Application for a non-material amendment following a grant of planning permission.

Approval of reserved matters following outline consent LU/47/11/ for the construction of 126 No. dwellings together with internal road network, car parking and landscaping

Reference number: LU/121/17/RES

We are seeking to replace the approved External Wall Finishes Plan Brick (ref 543_PL_SITE LAYOUT_107 Rev E) with a new plan (ref 543_PL_SITE LAYOUT_107 Rev G) which replaces the Edenhall Dolomite Cream Brick with the BrickWorks Langold Buff Stock.

Littlehampton Phase 2
Outer Central Core

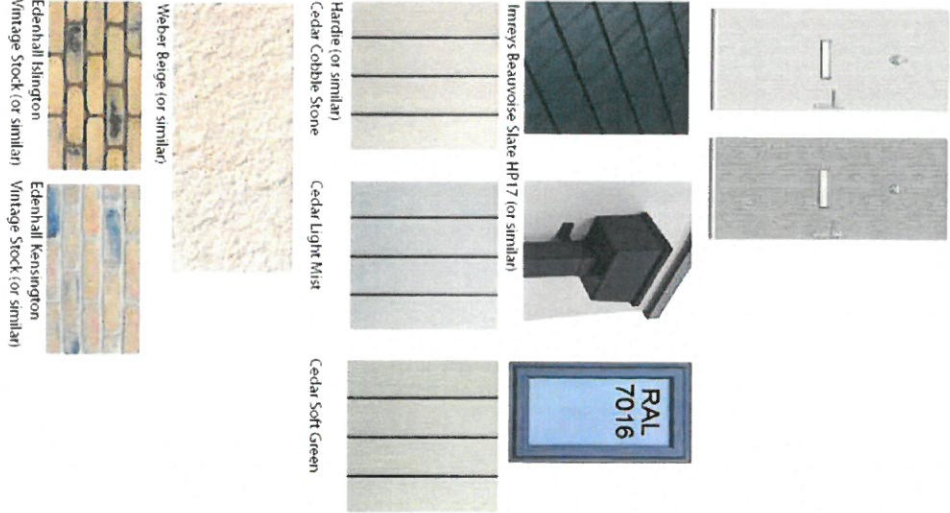
In addition, for clarity, we are proposing white garage doors throughout Phase 2 and the window frame proposed throughout Phase 2 will be 7016 Anthracite. Attached to this submission is an updated extract from the Design and Access Statement confirming the selected window frames.

543_PL_SITE LAYOUT_107 Rev G
